From: Thomas Callaway
Sent: 27 May 2015 16:43
To: Planning.Responses
Subject: RE: Planning Consultation on: R/105/15/PL

APPLICATION R/105/15/PL

Site Address: Princess Marina House 61 Seafield Road Rustington BN16
2JG

Description of Works: New area of interlocking grass-block system to North-East to provide for relocation of minibus parking (partial resubmission following R/307/14/PL).

JOB number:	drawing number:	revision:
2082	(11)001	1
project:	Princess Marina House	
client:	Seaside Apartments	
client:	RAF Benevolent Fund	
title:	Parking Plan	
date:	22/04/15	scale:
	1:100 @ A1	drawn: GT
		checked: CS

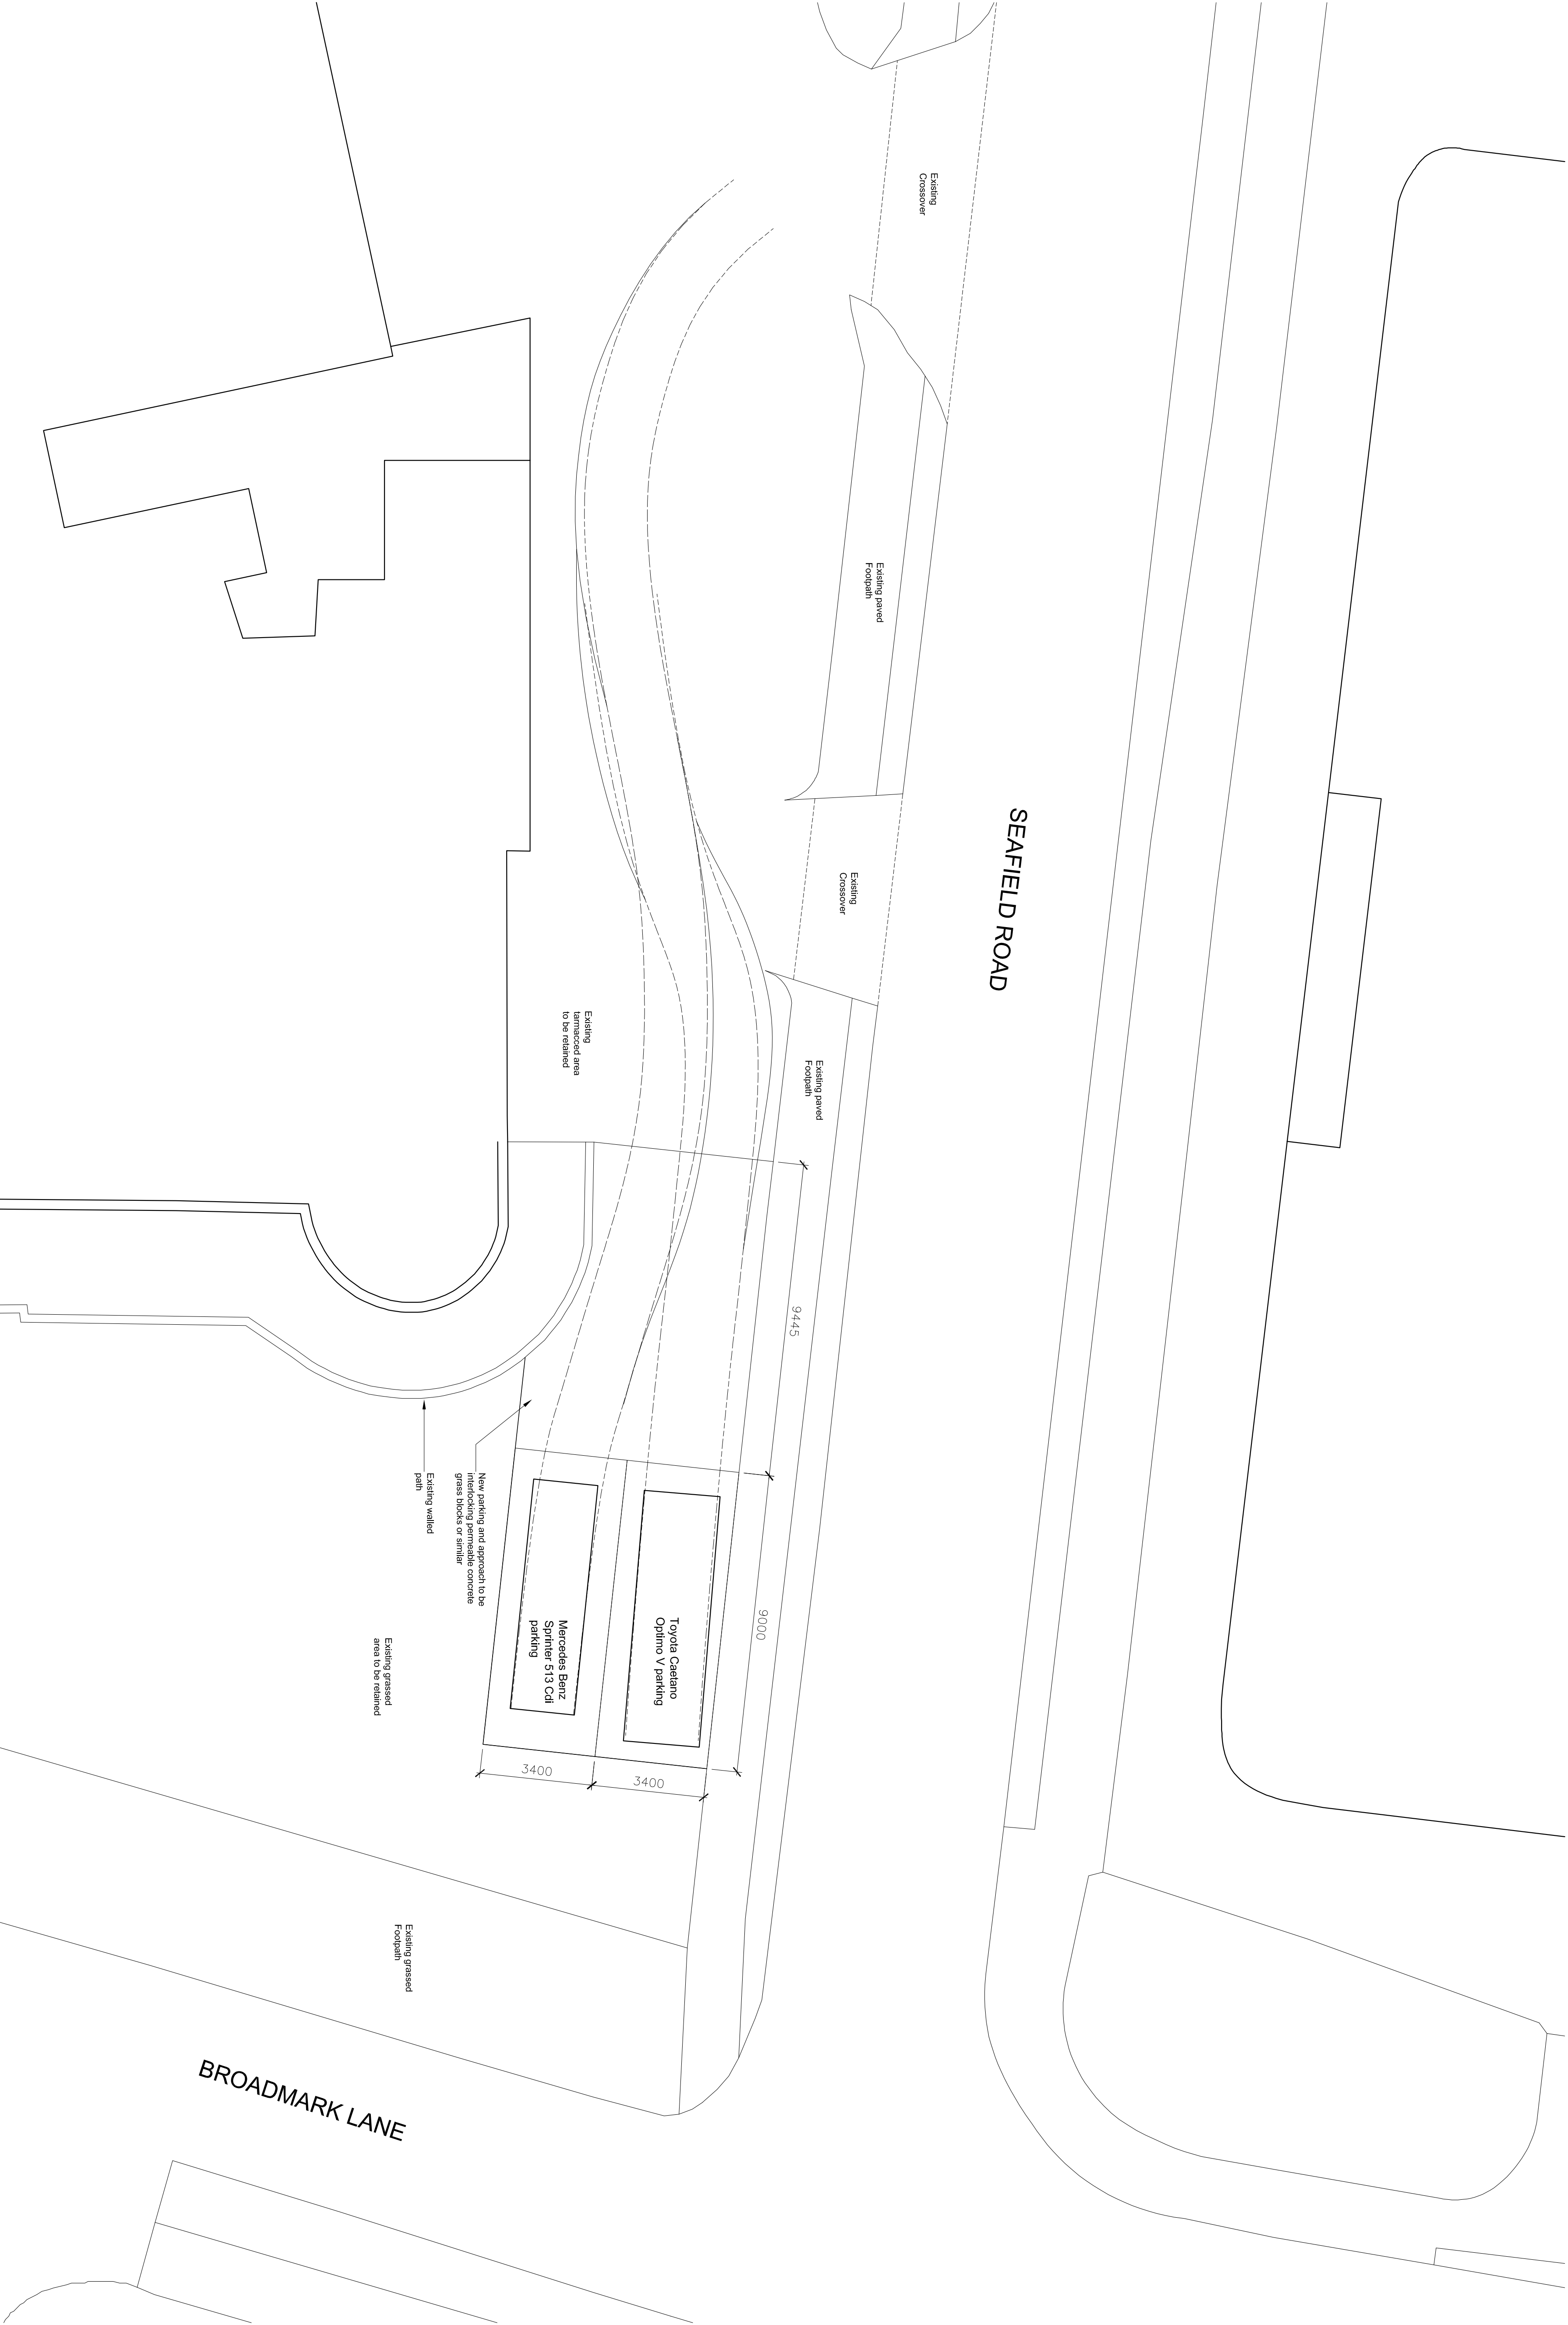
No surface water drainage comments as the parking area appears to be a permeable construction.
